Hi Emma,

I refer to the points identified below in the email from AP&S and provide the following comments:

Road Reserve Width

BEWARE!

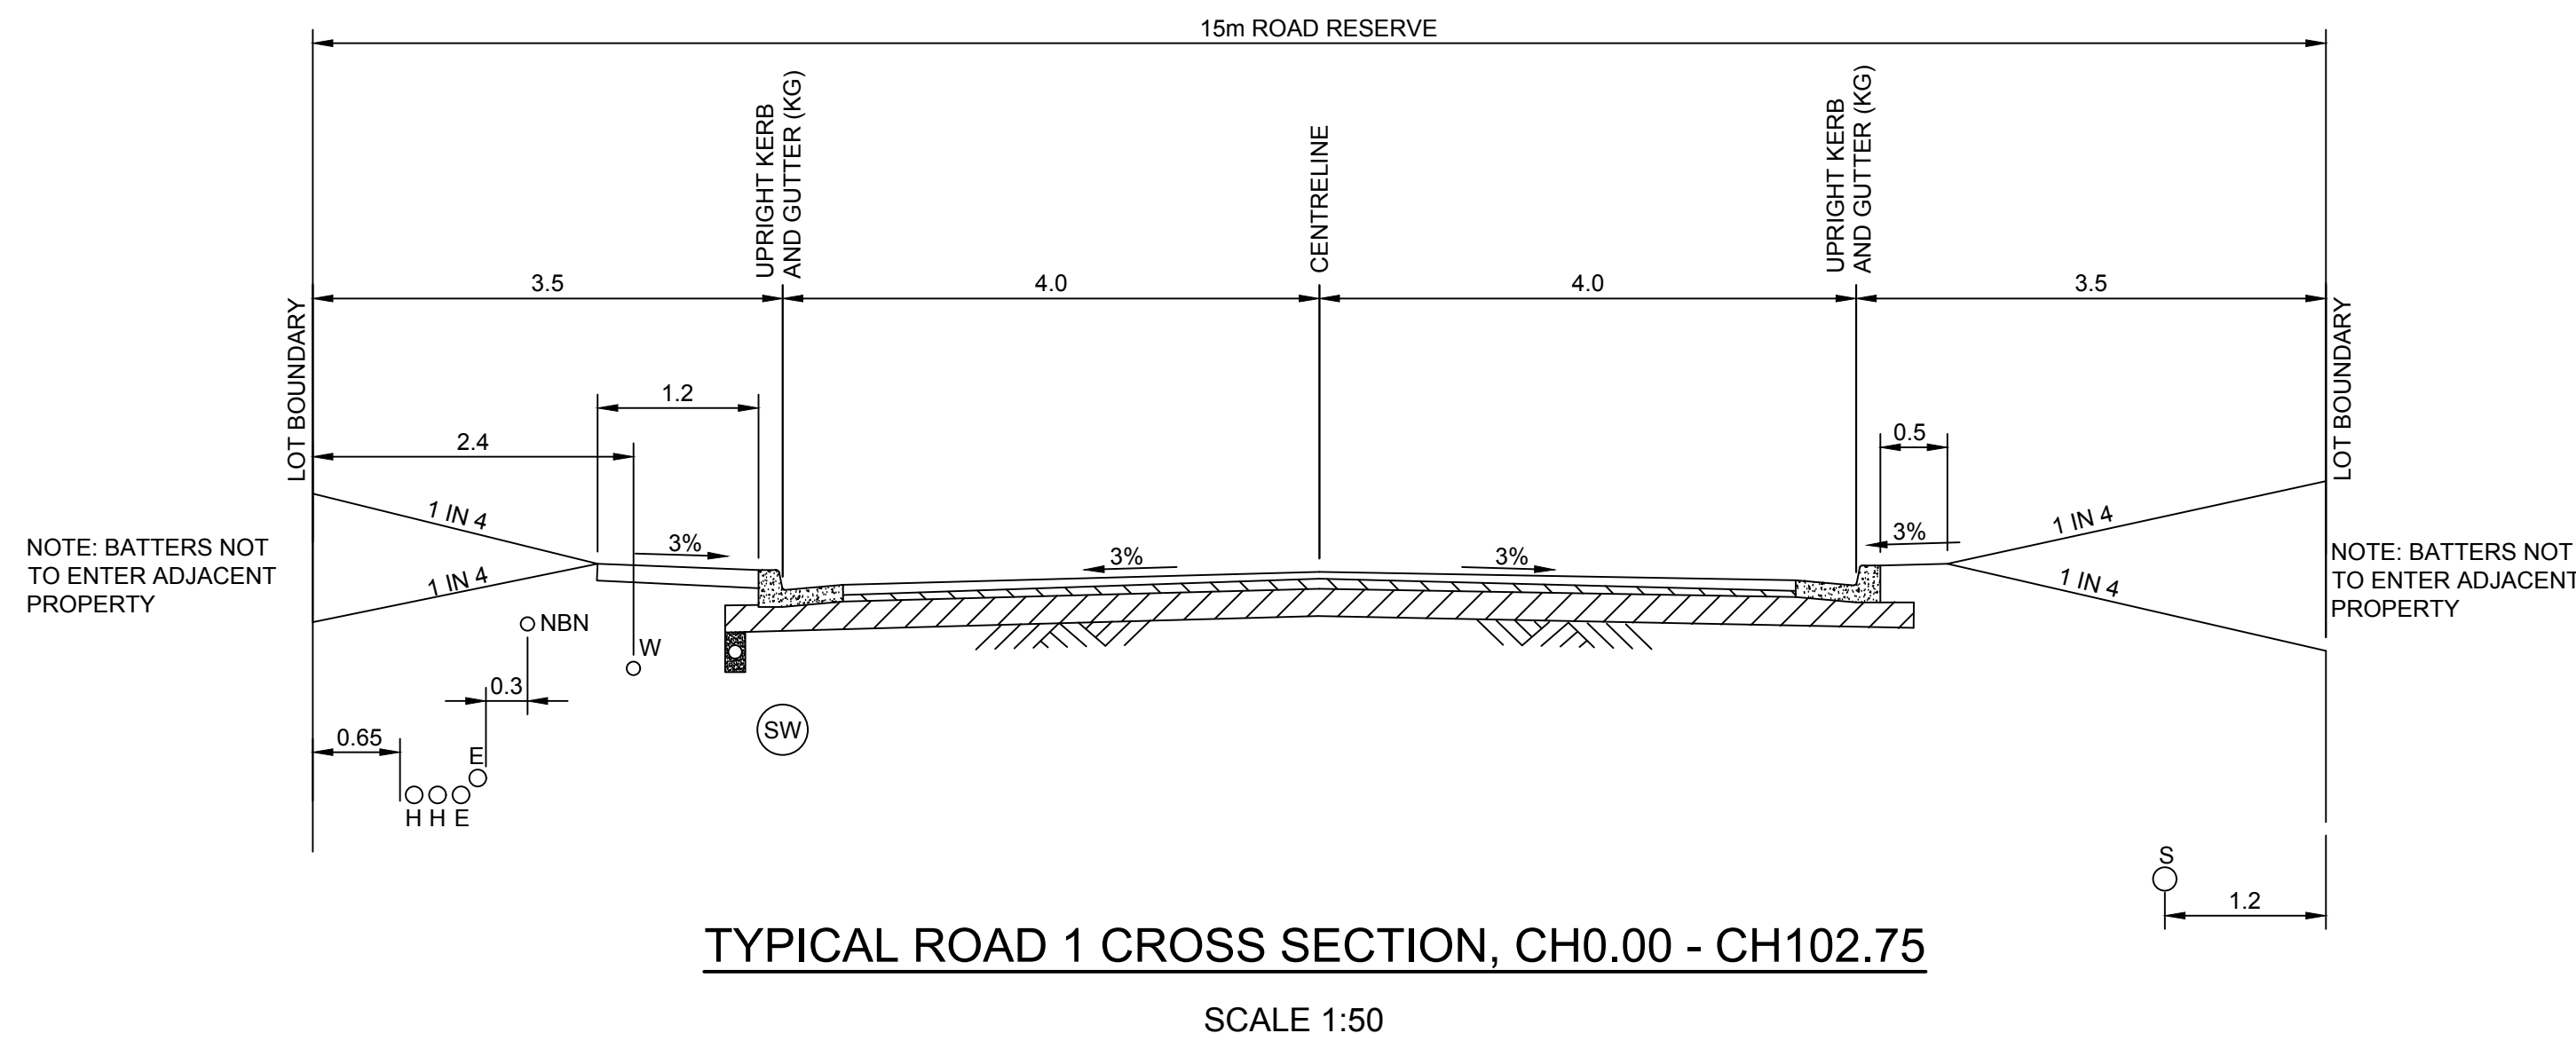
Council recognises the constraints of the layout and recommends the following road requirements.

- Road 1 (Entrance Road) CH0.00 to CH135.00,
 - 15m Road Reserve width as restricted by existing property boundary.
 - 7m wide carriageway (kerb invert to invert);
 - Upright Kerb – No property driveway required on this section of road
 - 2m width shared path on northern side

- Road 1 (Loop Road) CH135.00 - CH414.25 & CH135.00 - END
 - 16m Road Reserve width as per SDCP2014 Chapter G11.
 - 7m wide carriageway (kerb invert to invert);
 - Layback Kerb – for dwelling driveway;

- Road 1 (Section A) adjoining public reserve
 - **16m** Road Reserve width as per SDCP2014 Chapter G11.
 - **7m** wide carriageway (kerb invert to invert);
 - **Upright Kerb** – No property driveway required on this section of road;
 - **Open swale drain to** connect overland flow from drainage easement along the eastern side boundary of Lot 23 to drainage easement along eastern boundary of Lot 63,
 - **Multi-purpose:**
 1. for stormwater drainage management (to minimise overland run-off on road from northern drainage easement to Road 1 then discharge back to southern easement) and
 2. restrict future driveway access to existing dwellings on eastern side of subdivision

- Condition C9. 1) c. The entrance road shall have a 15m road reserve width with a 7m wide carriageway (kerb invert to invert) with upright kerb. The loop road shall have a 16m road reserve width with a 7m wide carriageway (kerb invert to invert) with layback kerb. Upright kerb is to be used on the section of road adjoining the public reserve. *(the remainder of C9.1c) to continue as per draft)*
- New condition C12 d) An open swale drain is to be constructed within the 2m wide public reserve to connect the overland flow from the drainage easement along the eastern side boundary of Lot 23 to the drainage easement along the eastern boundary of Lot 63
